DRAWING SCHEDULE		
		SITE DEVELOPMENT PLAN MARCH 26, 2024
SHEET	DESCRIPTION	
E01	LEGEND AND GENERAL NOTES	
E02	PHOTOMETRIC STUDY	
E03	LIGHTING CUT SHEETS	
TOTAL SHEETS IN ISSUE:		3

Plan Review

BLACK FOREST MAINTENANCE FACILITY  
SITE PHOTOMETRIC PLAN

E01

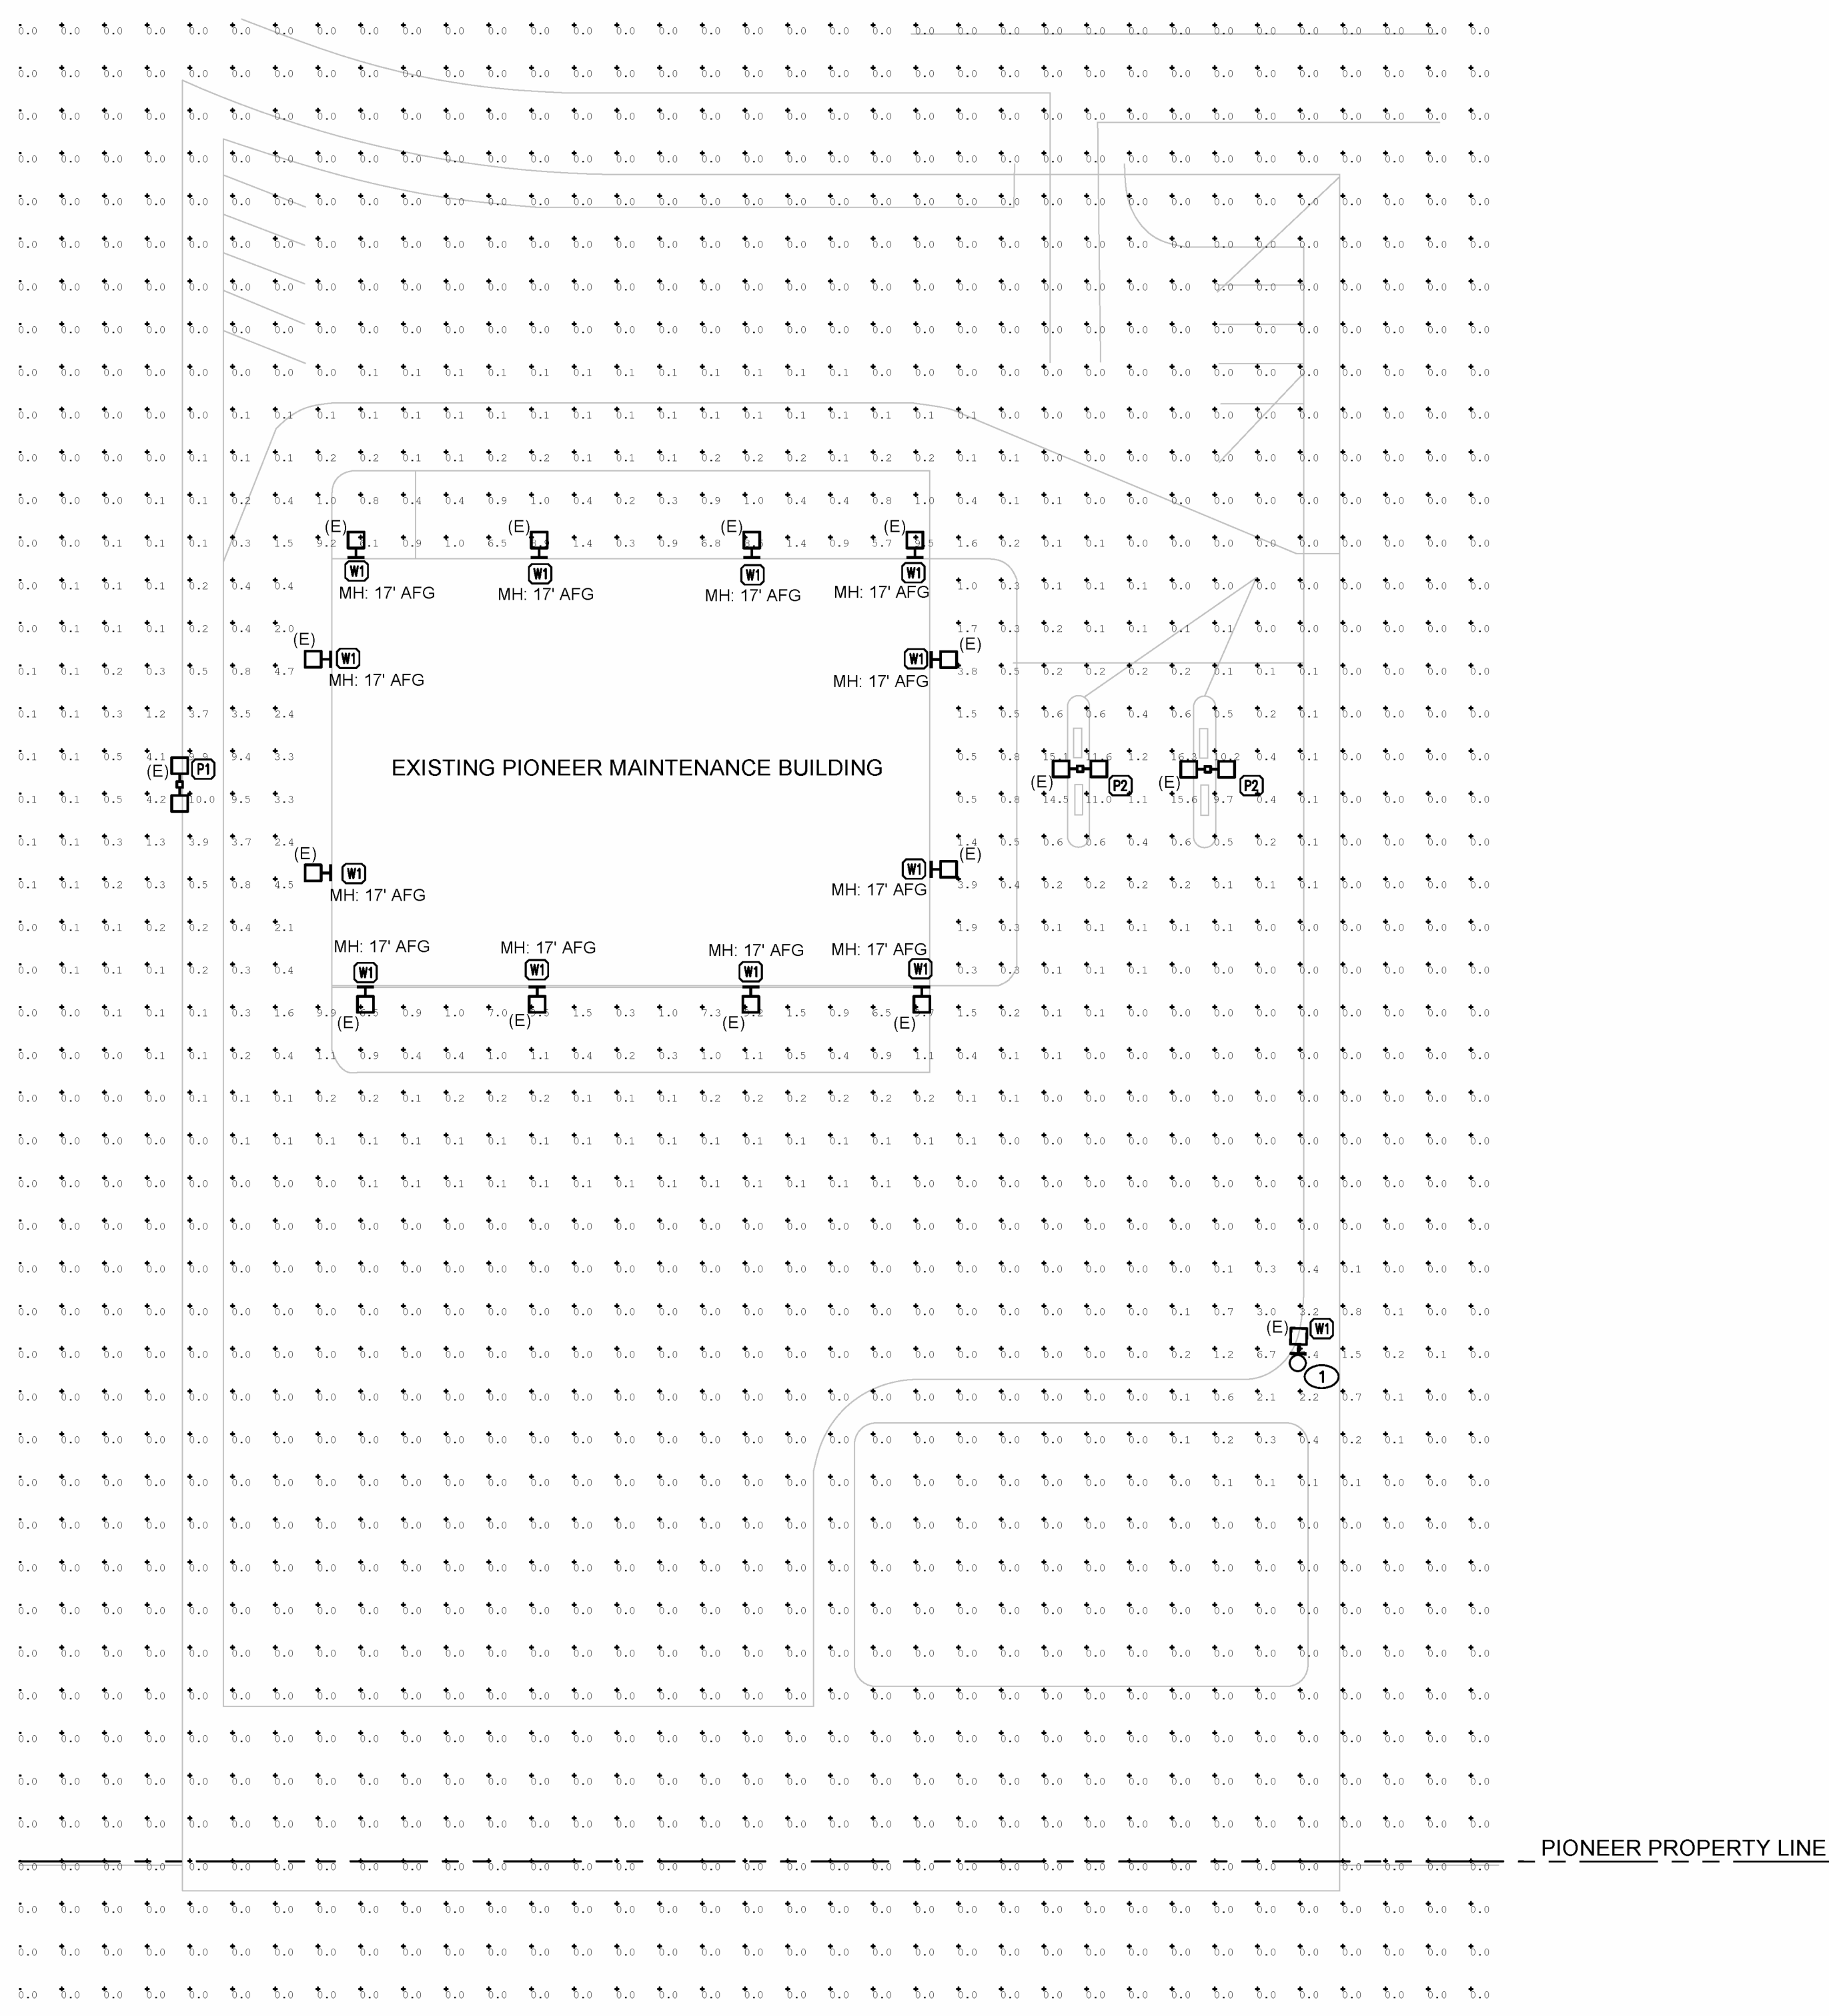
All new fixtures to be downlit in fixed position.
